Ask for:	Erika Davies
Telephone:	01832 742207
Planning Services	Planning.ENC@northnorthants.gov.uk
Our Ref:	NE/21/00969/FUL
Your Ref:	PP-09945176
Date:	23 June 2021

Proposal : **Single storey rear extension; first floor extension to create an additional bedroom and addition of front canopy at Manorfields Caldecott Chelveston Wellingborough Northamptonshire NN9 6AR .**

I refer to the above application received on **16 June 2021** but have to advise you that it is **INVALID/INCOMPLETE**. In order to enable further progress to be made, please supply the following:

EXISTING PLANS

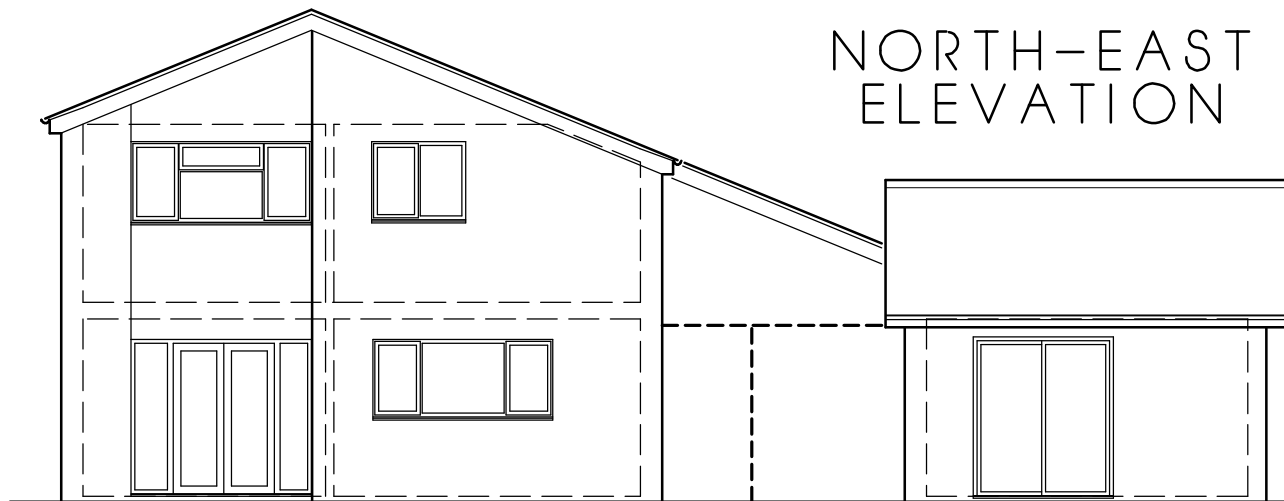
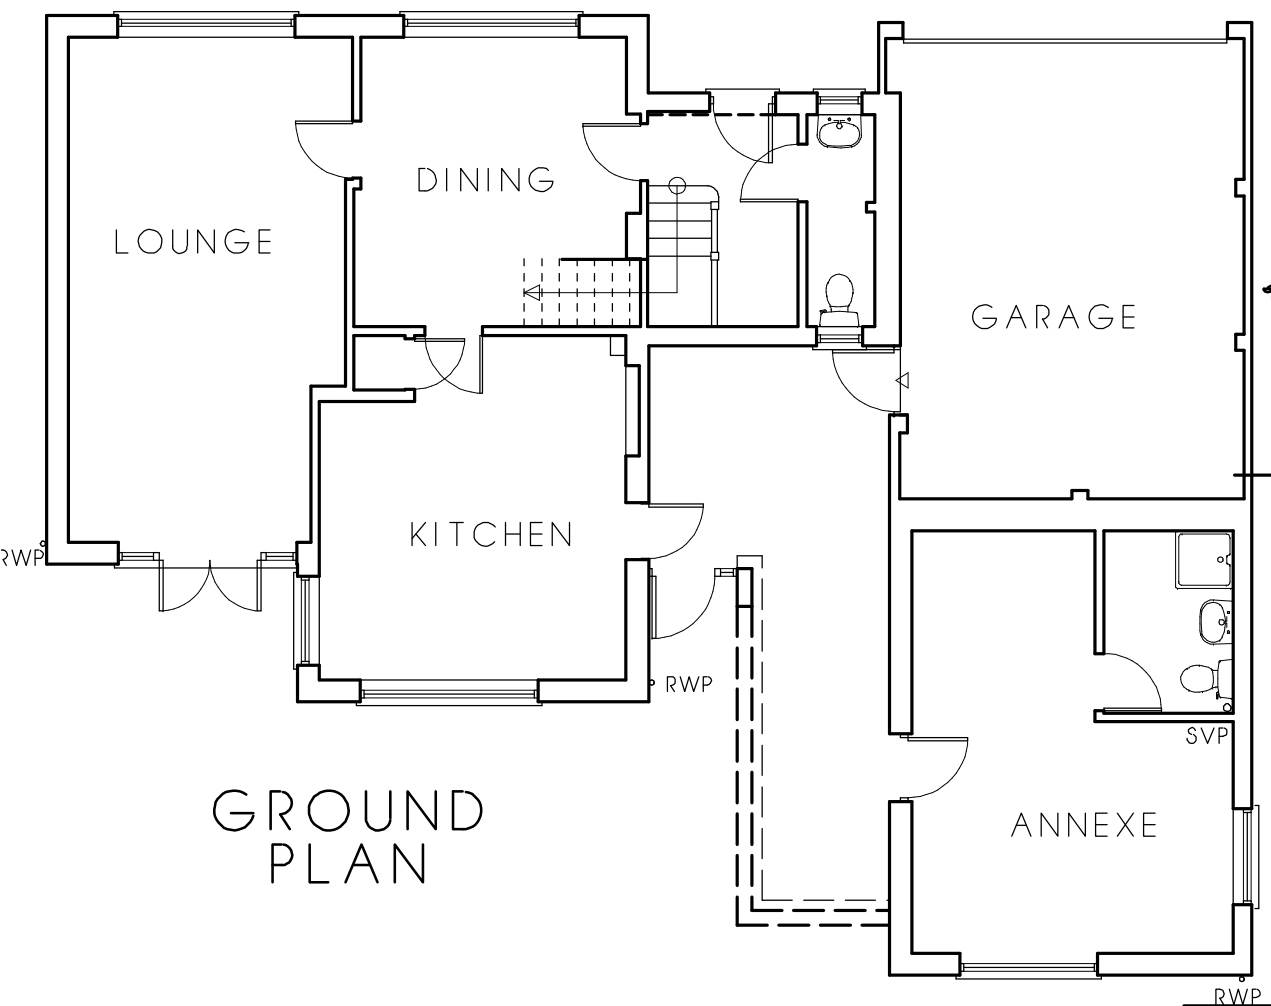
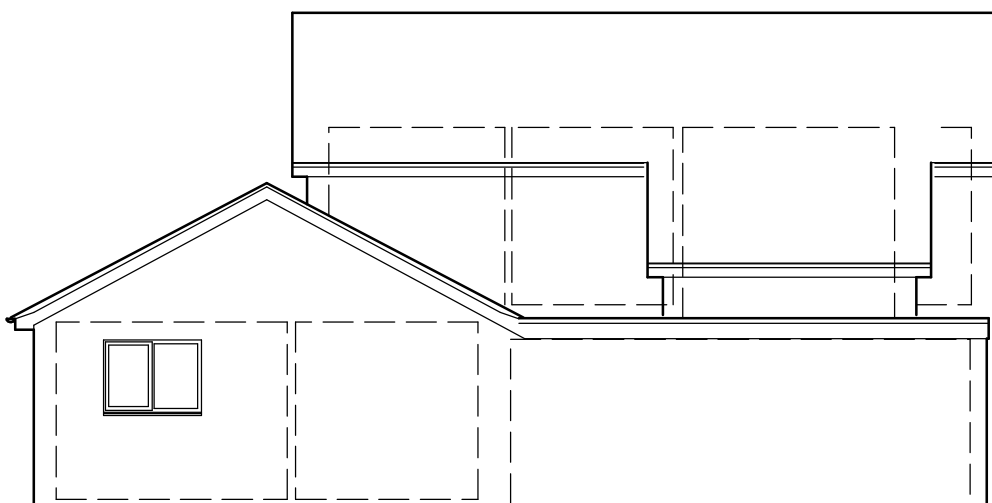
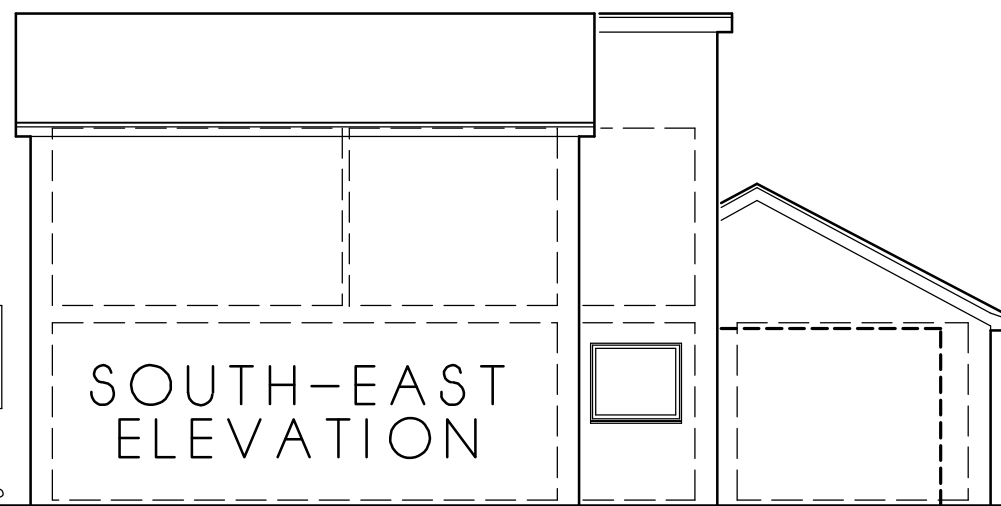
3. Thank you for the drawings submitted with your application, even though the scale used has been given no dimensions have been provided, additionally the existing elevations appear to be mislabelled and do not match the proposed elevations with two of the existing elevations identified as "South- West Elevation". As per our published Local Requirements, "All plans and drawings must be drawn to an appropriate metric scale (1:50 or 1:100) and have all relevant dimensions of the key elements of the proposal clearly written. This includes the height, length, width and (if relevant) the distance from the site boundary of any proposed works. We

Please provide amended drawings including all relevant dimensions of the proposal:

- Dimensions for the existing and proposed floor plan;
- Dimensions for the existing and proposed elevations annotated with all height dimensions and clearly identified;
